A303 Amesbury to Berwick Down

Proposed development consent order

RESPONSE TO WILTSHIRE COUNCIL'S WRITTEN REPRESENTATIONS BY THE TRAIL RIDERS' FELLOWSHIP

EXISTING A303 STOPPED UP, NO CHANGE TO BYWAY AMES 12

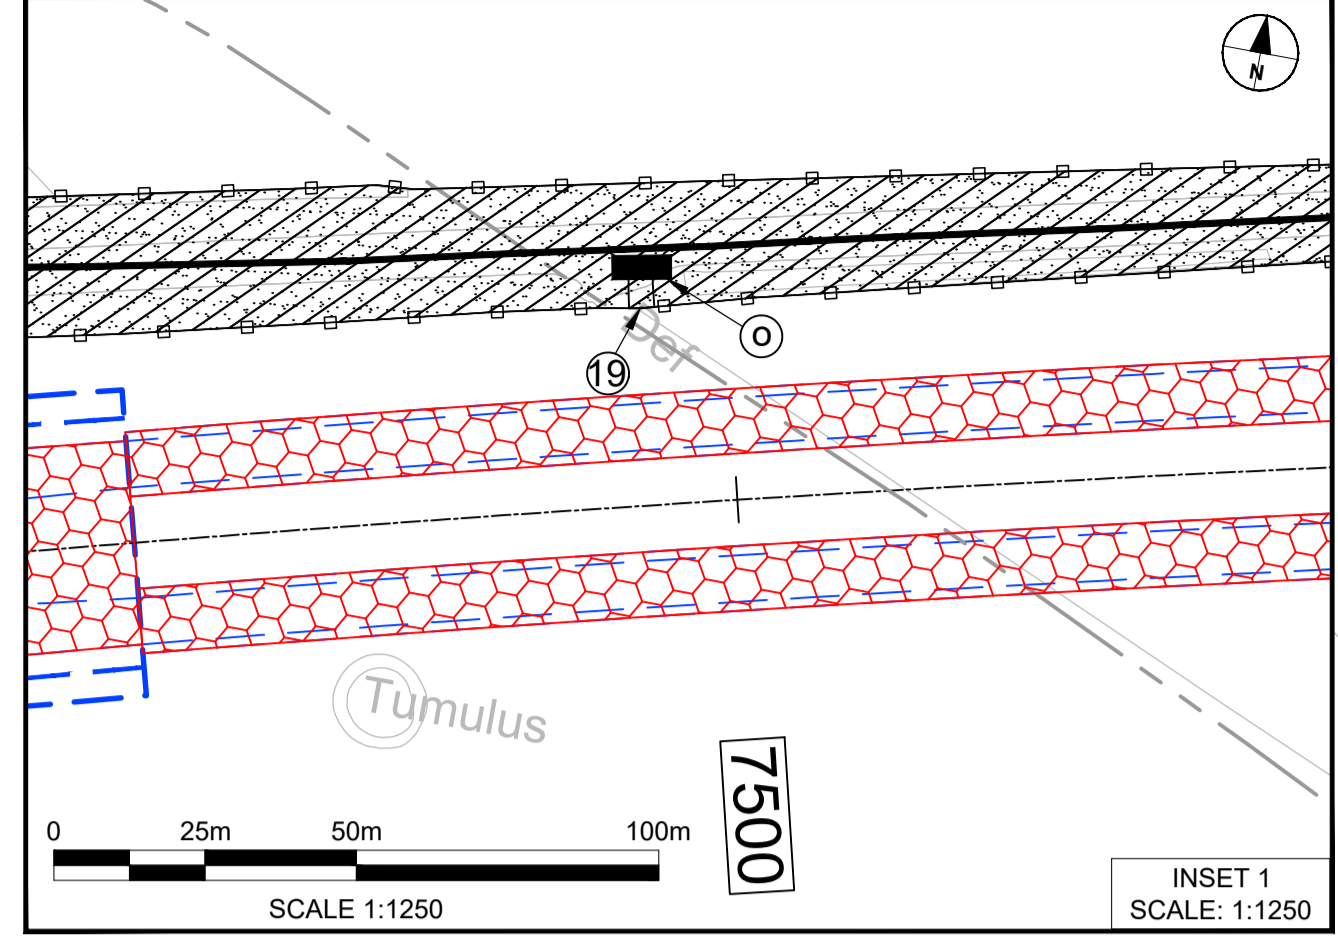
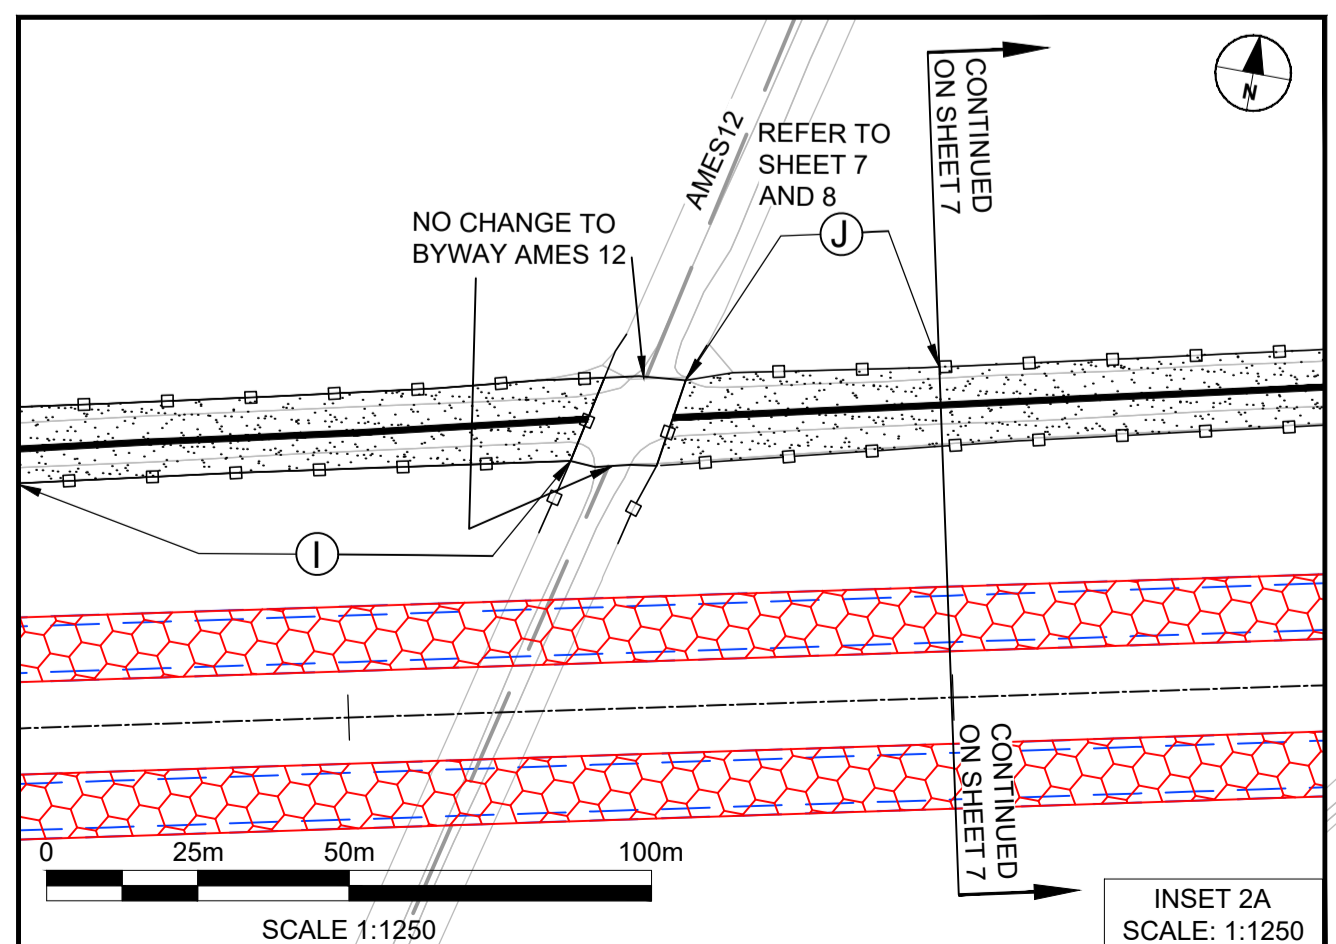
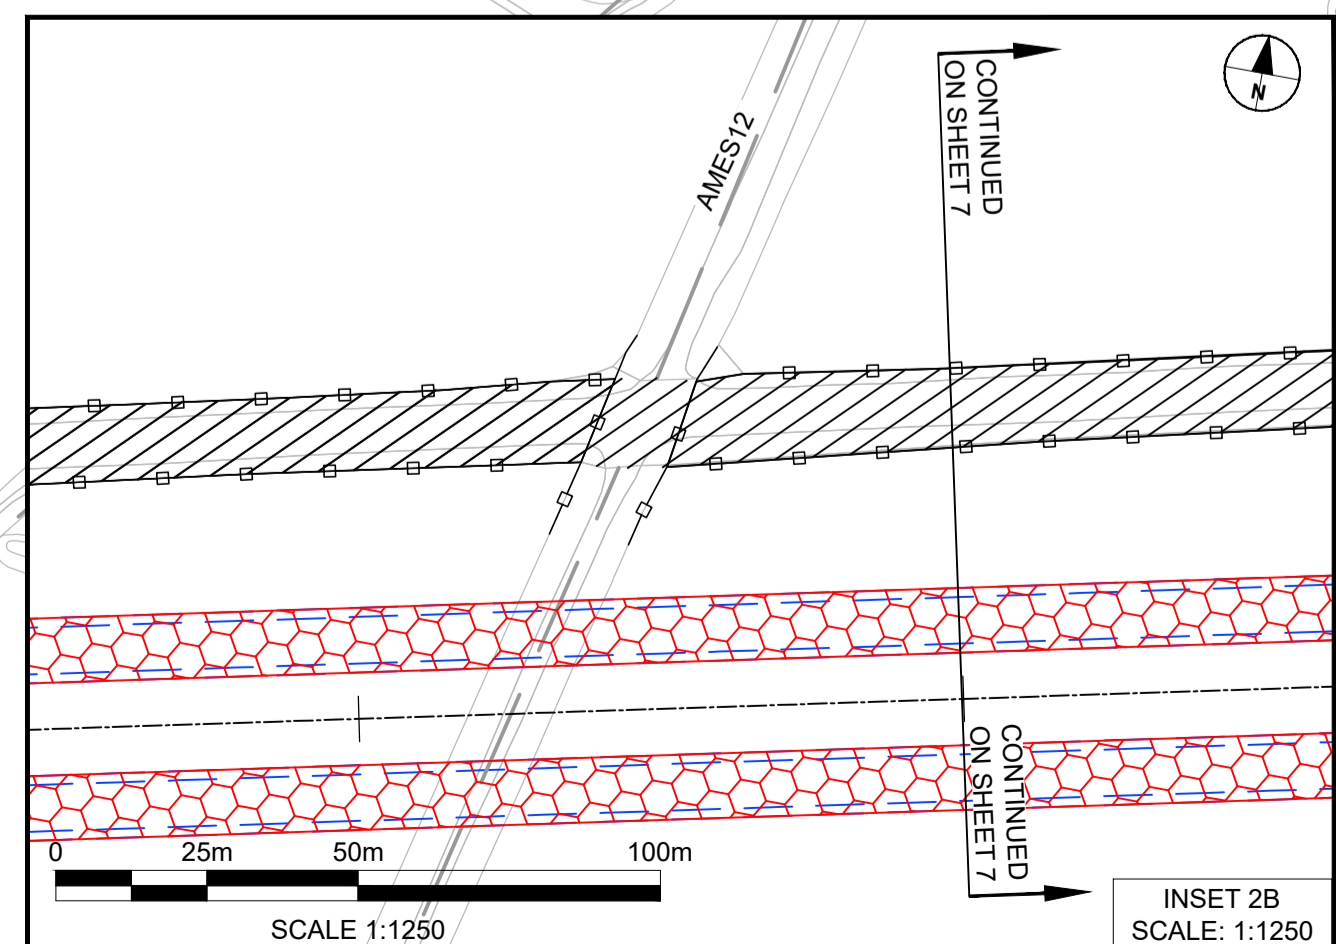
2. TRF's principal concern is on the need to maintain a local connection between byways 11 and 12 and also to ensure that the use of the A303 is not lost to small-capacity motorcycles.

3. The Highways England scheme has always proposed that the line of the 'old' A303 should become a restricted byway ("RB") by a process of extinguishing highway rights over the A303, and creating by order a new RB to cater for non-motorised public traffic, including disabled persons using powered mobility scooters, and for motorised private access traffic along the same route. One problem with this is that such traffic is not generally permitted to use a RB.¹

6. TRF welcomes (and agrees with) Wiltshire Council’s view that motorcycles are not likely to have a significant impact on the byways, and submits to the Examining Panel that this applies equally (if not more strongly) to the ‘old’ A303. To put this as a simple term for minor amendment of the proposed DCO:

6.1. Do not extinguish public highway rights along the entire width of the ‘old’ A303 and create by order a new restricted byway. Instead stop-up part of the width, and leave the existing public right of way on the residual width and regulate the traffic along it by means of a traffic regulation order.

7.1. Provide the link between byways 11 and 12 as originally proposed by Highways England, and in so doing will satisfy the principal limb of TRF’s representations;

7.2. Provide a continuing right of way for the public with mobility scooters;

7.3. Provide a continuing right of way for ‘land management traffic’;

7.4. Potentially provide a right of way for 50cc motorcycles for the length of ‘old’ A303 proposed to be closed;

7.5. Not prevent the removal of the blacktop surface of the ‘old’ A303, not prevent part of the width being stopped-up if required; and

7.6. Deliver certainty that the overground A303 would no longer be part of the ordinary network – let alone the strategic road network (i.e. classified roads): it would provide a solution that made it extremely unlikely that the overground

12.7. Is within the scope of the DCO simply by the Examining Authority recommending that the closure of the 'old' A303 is only for part of the width, and for the remainder of the width closure for MPVs be replaced by traffic order management.
